Item No. Report of the Interim Director of Planning, Regeneration & Public Realm

Address: 63 LONG DRIVE RUISLIP

Development: Erection of a part single storey, part double storey rear and first floor side extension

LBH Ref Nos: 47034/APP/2022/3861

title
PROPOSED ELEVATIONS

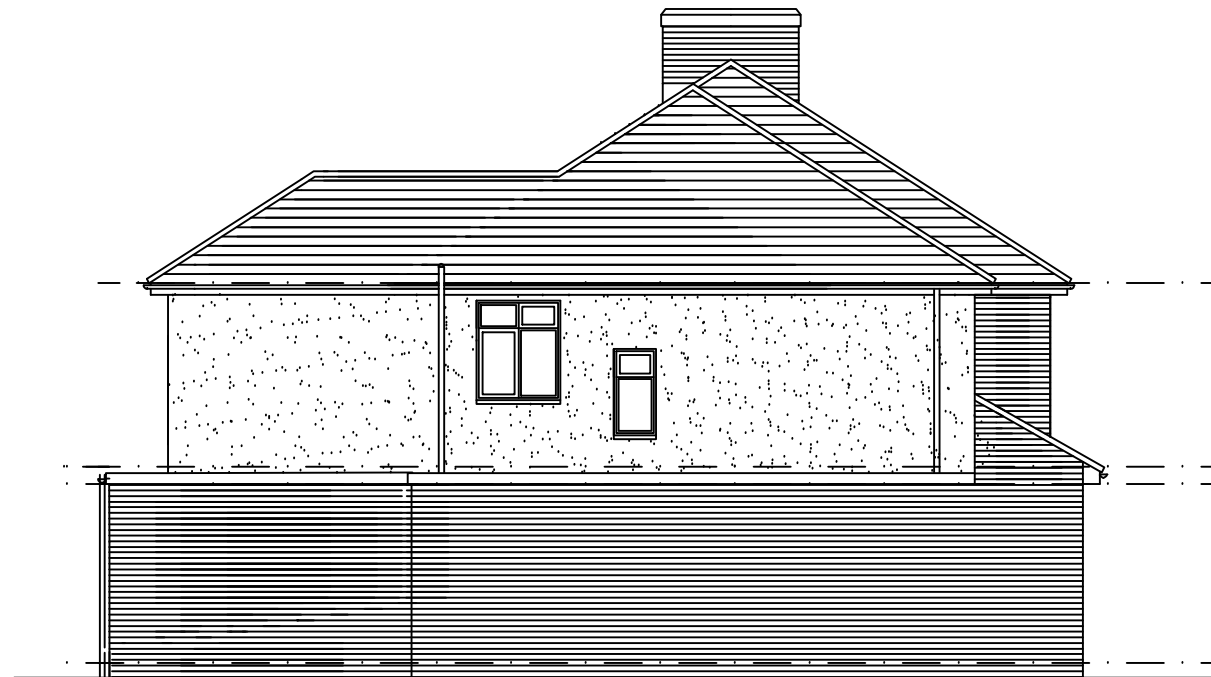
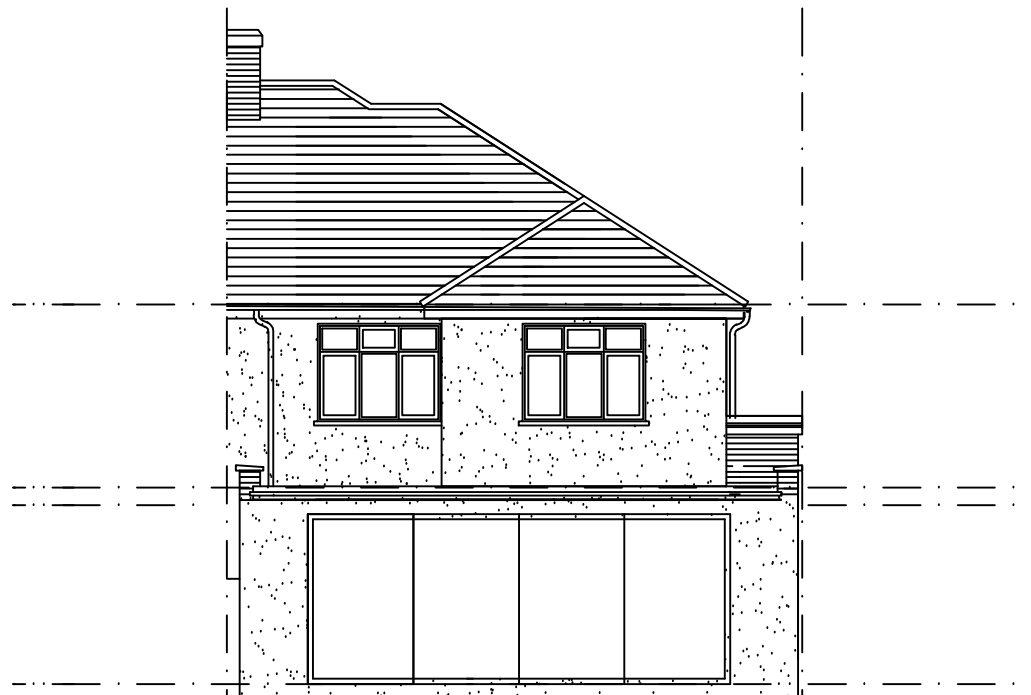
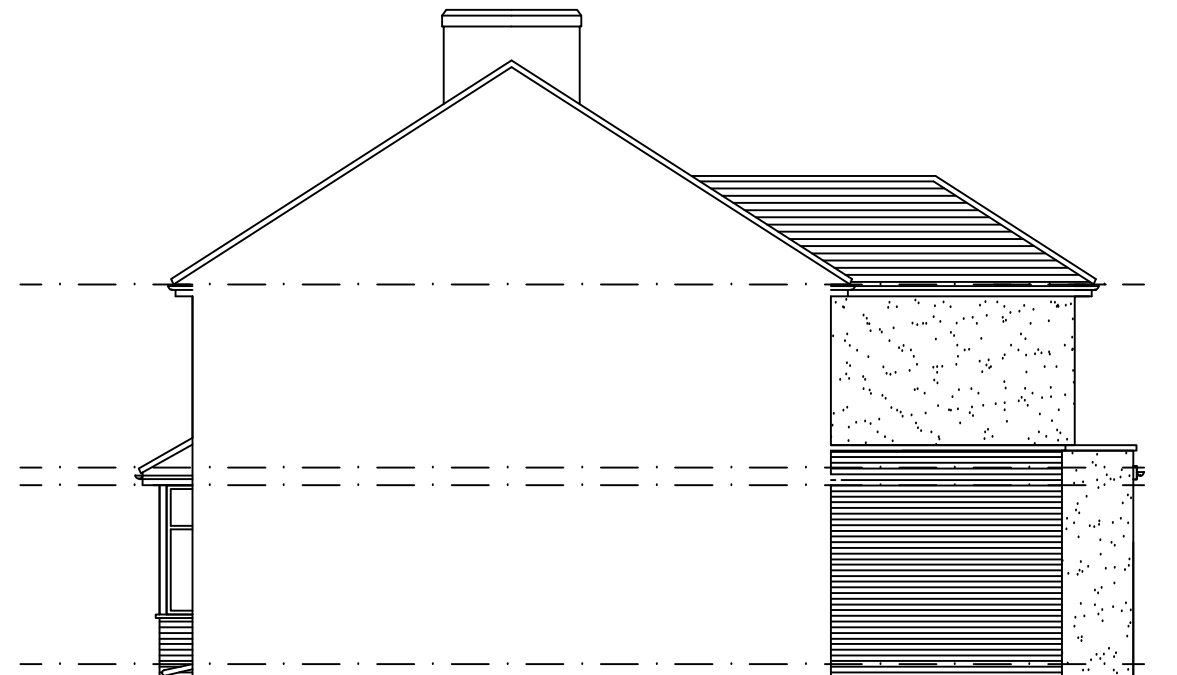
The infill side/rear element would project 4m deep to match the existing rear extension, with a maximum height of 2.68m, characterised through a flat roof. The first floor element would be 3.2m and 3.8m in width, substantially set down from the main roof ridge with a hipped roof form. Whilst the proposal would be deeper than the prescribed measurements set out in Policy DMHD1, it would still appear subordinate to the host dwelling and within the character of the wider area, where development to the rear of dwellings is a common feature.

No 69 has been extended by way of rear extension, however it is not full width. The property sits further forward on its plot relative to the application property, resulting in the side extension and proposed infill element presenting itself as an imposing built form along this boundary. Notably, on the side closest to the boundary there is a window on the rear elevation of No 69, which would be severely impacted through loss of light and outlook through this infill element. Whilst it is noted that the side extension is existing, a further projection of 4m on the boundary would result in a 6m built form on this boundary, exacerbating the harm to this window significantly, through loss of light, outlook and appearing as an overbearing form of development. The main terrace space directly outside the rear doors would also be affected in a harmful way.

As such, the proposal as a whole would be harmful to the amenities of the occupiers of No 69 Long Drive through its size, siting, bulk and massing resulting in a loss of outlook, light and appear as an overbearing form of development, contrary to Policies DMHD1 and DMHB11 of the Hillingdon Local Plan Part Two (2020).

The proposed development, by reason of its depth, proximity, bulk and mass would be harmful to the amenities of the occupiers of No 69 Long Drive, causing a harmful loss of outlook, loss of light and sense of enclosure, all contrary to Policies DMHD1 and DMHB11 of the Hillingdon Local Plan Part Two (2020).

| <b>title</b>                                                                                                                                        | PROPOSED FLOOR AND ROOF PLANS                    |

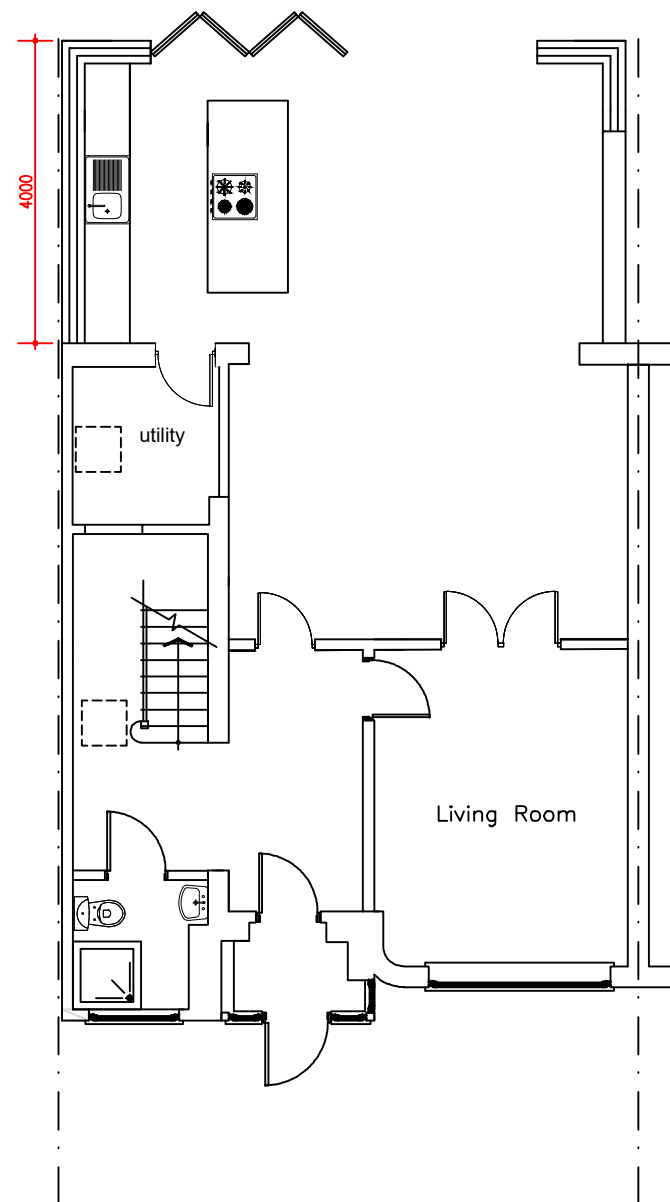
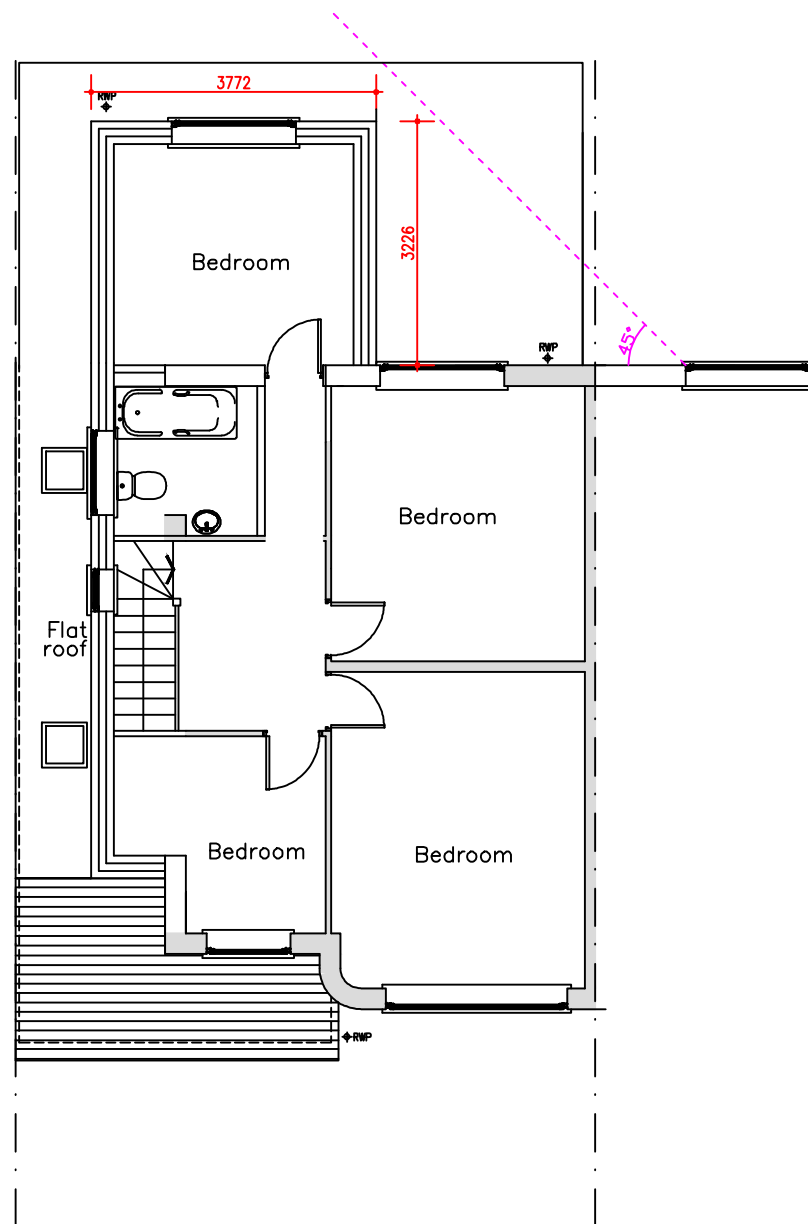
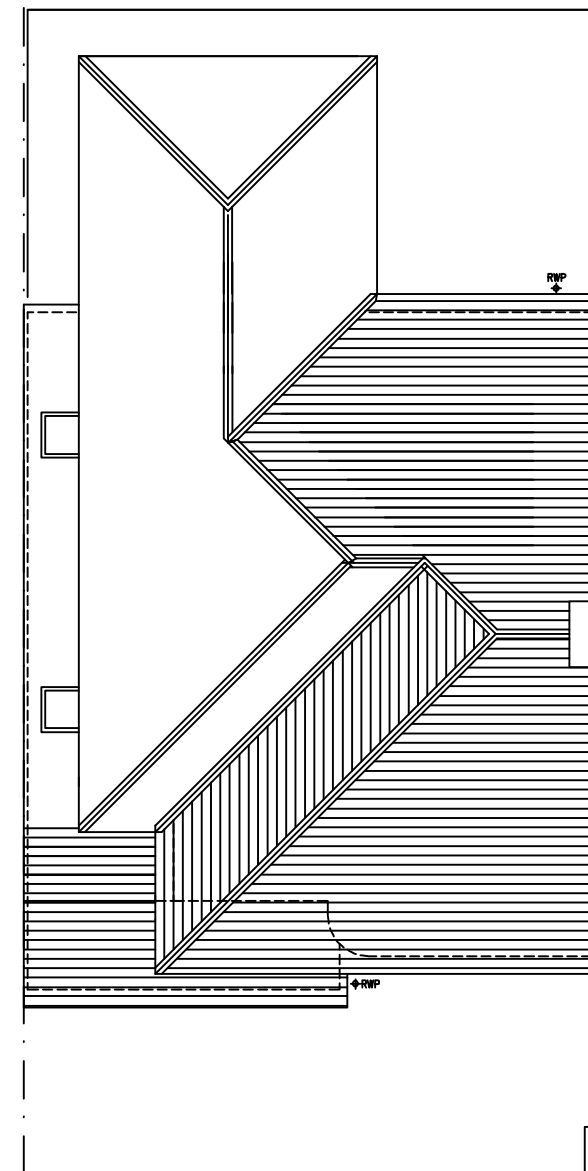
No 61 would not be impacted by the ground floor element. The first floor element has been shown not to impede on the 45 degree sight line and would be set off from the boundary to a substantial degree. As such, it would be unlikely to cause undue harm to the amenities of the neighbouring occupiers at No 61 Long Drive.

At first floor level, no 45 degree sight line has been provided by the applicant for No 69, however the window closest to this boundary at first floor level appears to serve a bathroom, with the closest habitable room view unlikely to be inhibited by the first floor element.
